**Atlas-Campaspe Mineral Sands Project**  
**Responses to the Department of the Environment Review Comments (dated 30 August 2013)**

**1.1.1 Commonwealth Government (30 August 2013) states:**

Indicative General Arrangement -  
Year 16

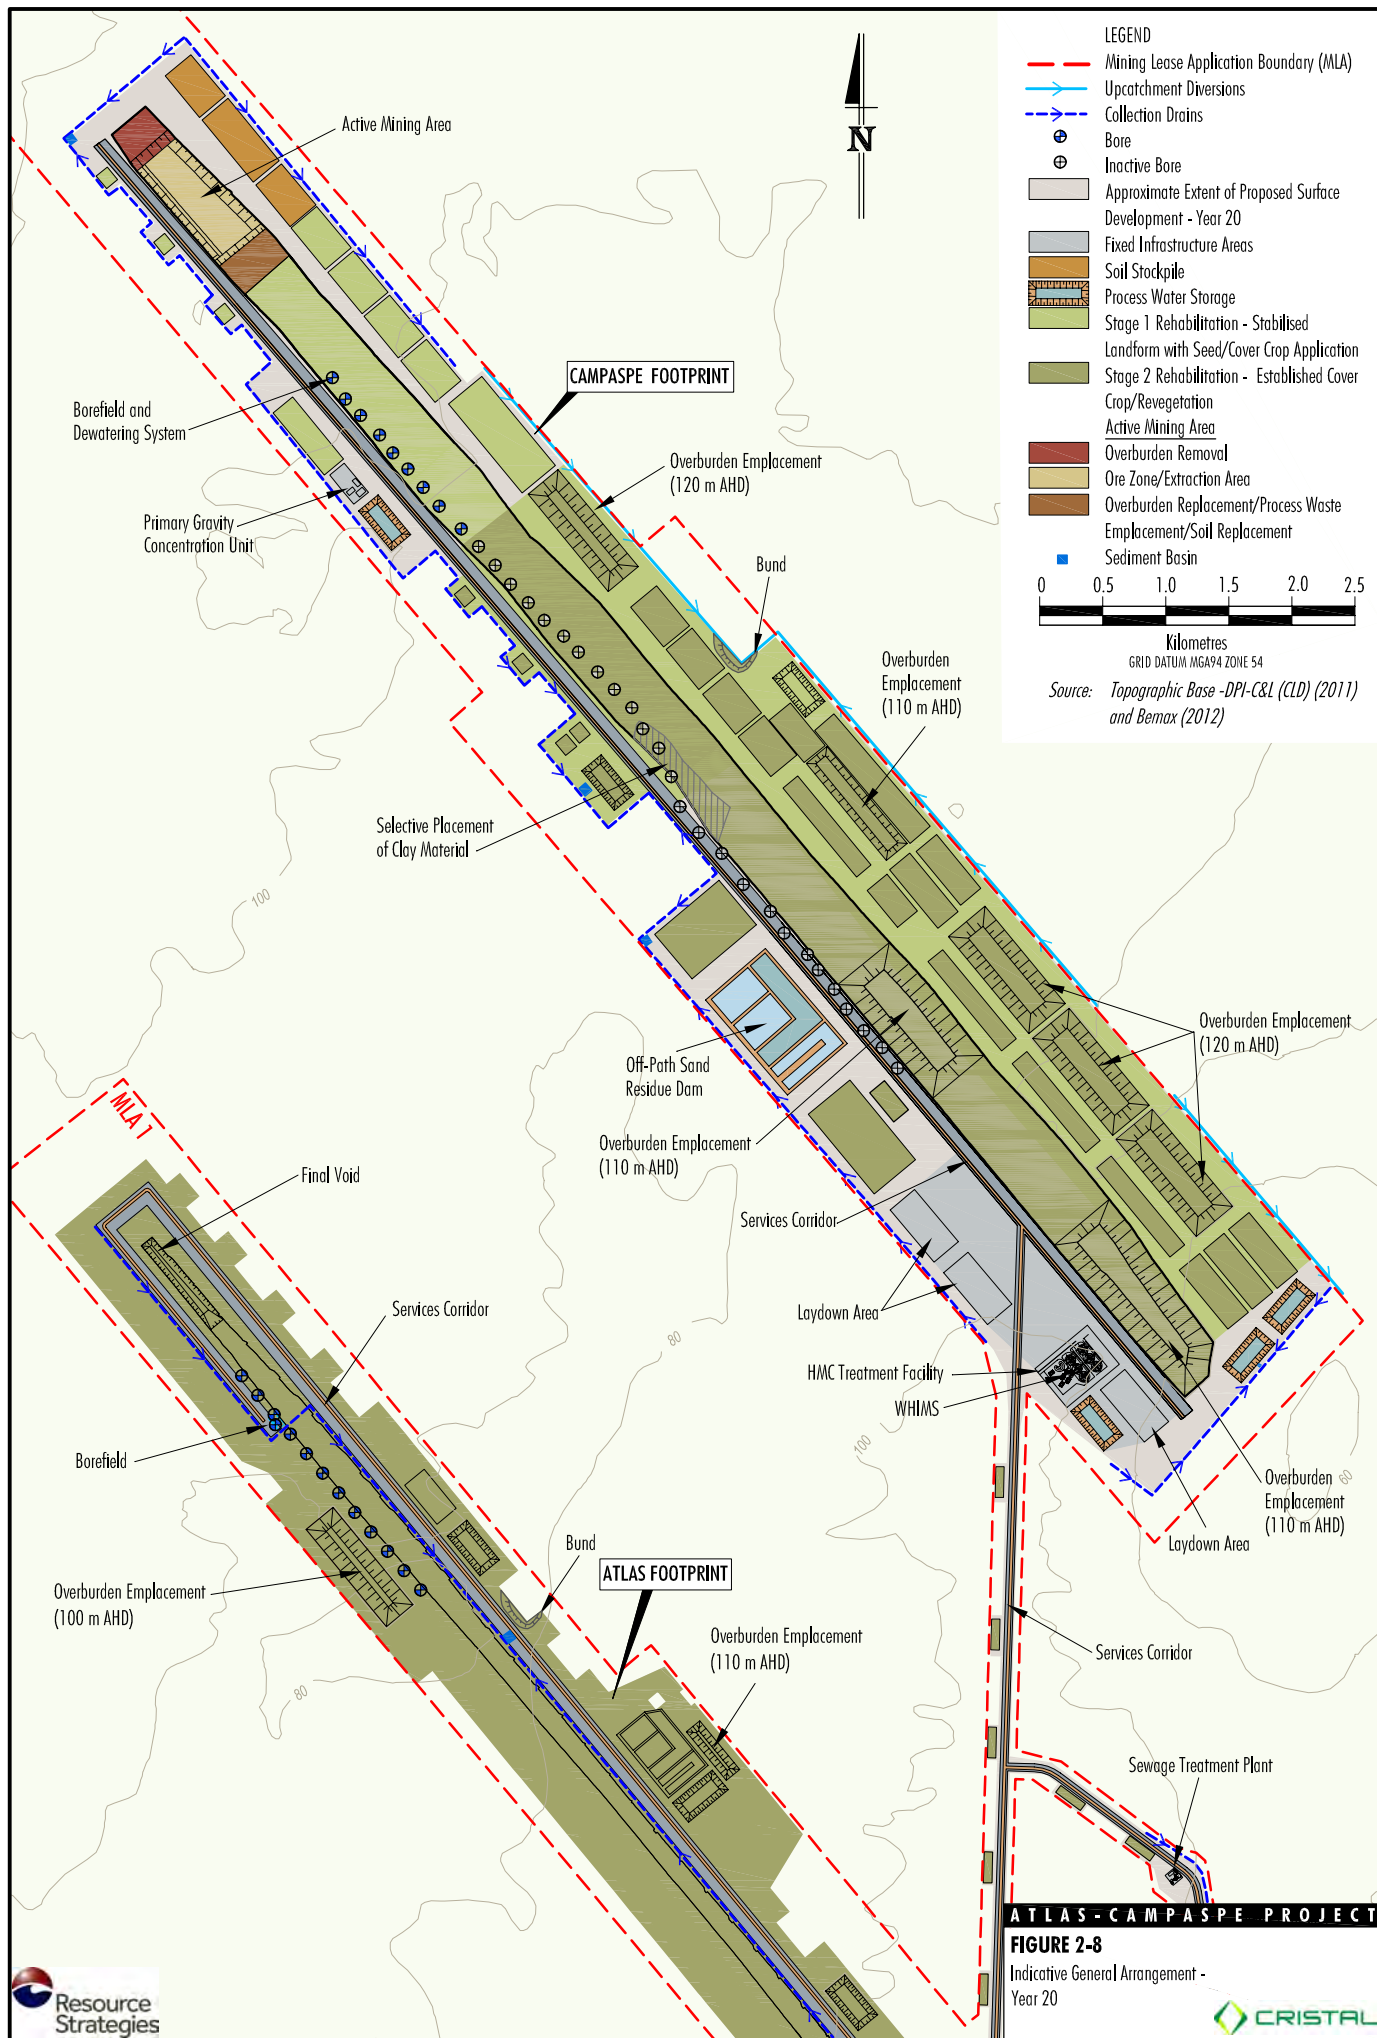
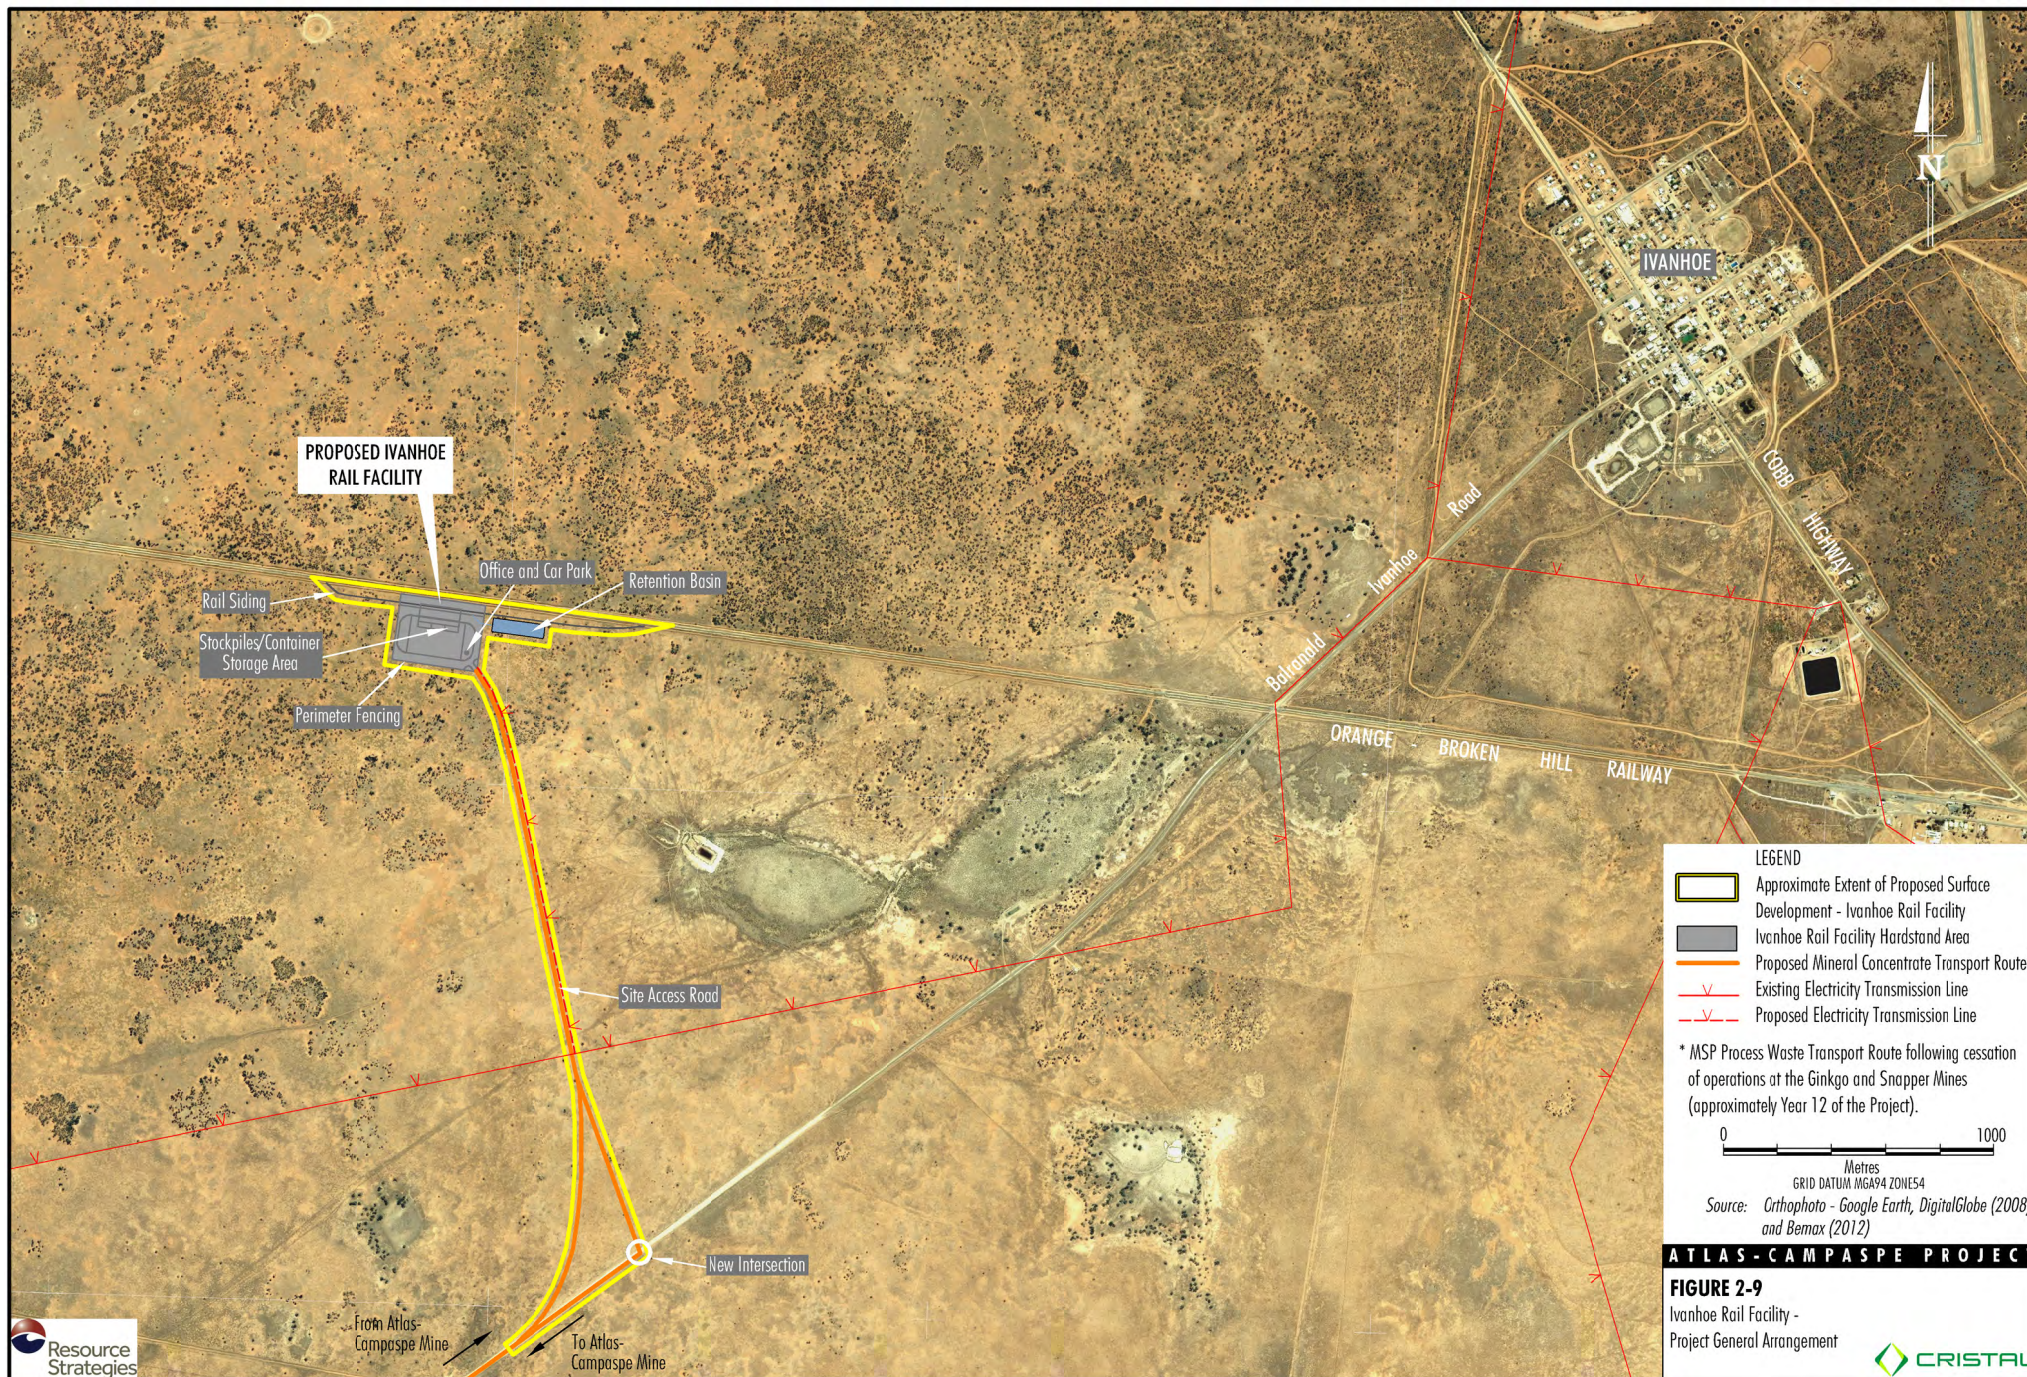
***Further detailed information about the proposed staging of rehabilitation works and how these relate to the timing and location of the advancing void is still required. Although the Department notes that these are depicted in the figures, we request further information about the timing of commencement of rehabilitation at particular areas in regards to the stage of extraction, and the progression of rehabilitation works in relation to the progression of the mine void.***

Rehabilitation would occur progressively over the 20 year life of the mine as shown on Figures 2-4 to 2-8 of the EIS. Mining areas (e.g. overburden emplacements and the backfilled mine path) would be rehabilitated as they are no longer required for mining operations and other mine infrastructure is rehabilitated as it is decommissioned.

Landform preparation (i.e. replacement of overburden, subsoil and topsoil) on mining areas would commence within three months of the area becoming available for rehabilitation (i.e. the area is no longer required for mining operations) (subject to favourable climatic conditions).

Revegetation of mining areas would commence within 12 months of the area becoming available for rehabilitation (i.e. the area is no longer required for mining operations) (subject to favourable climatic conditions). Revegetation activities would be conducted on an annual basis during late autumn/early winter (i.e. prior to the winter rains) to maximise the potential for successful revegetation.

Table 3 provides further detail regarding the timing of commencement of rehabilitation at particular areas in regards to the stage of extraction, and the progression of rehabilitation works in relation to the progression of the mine void.

Year	Approximate Area (ha) of Rehabilitation (as shown on Figures 2-4 to 2-8 of the EIS)	Location of the Active Mining Area (as shown on Figures 2-4 to 2-8 of the EIS)
2	0	Southern end of the Atlas Footprint
5	360	Northern end of the Atlas Footprint
6	610	Southern end of the Campaspe Footprint
16	2120	Mid-way along the Campaspe Footprint
20	2330 (+ 600 ha of Stage 1 rehabilitation)	Northern end of the Campaspe Footprint
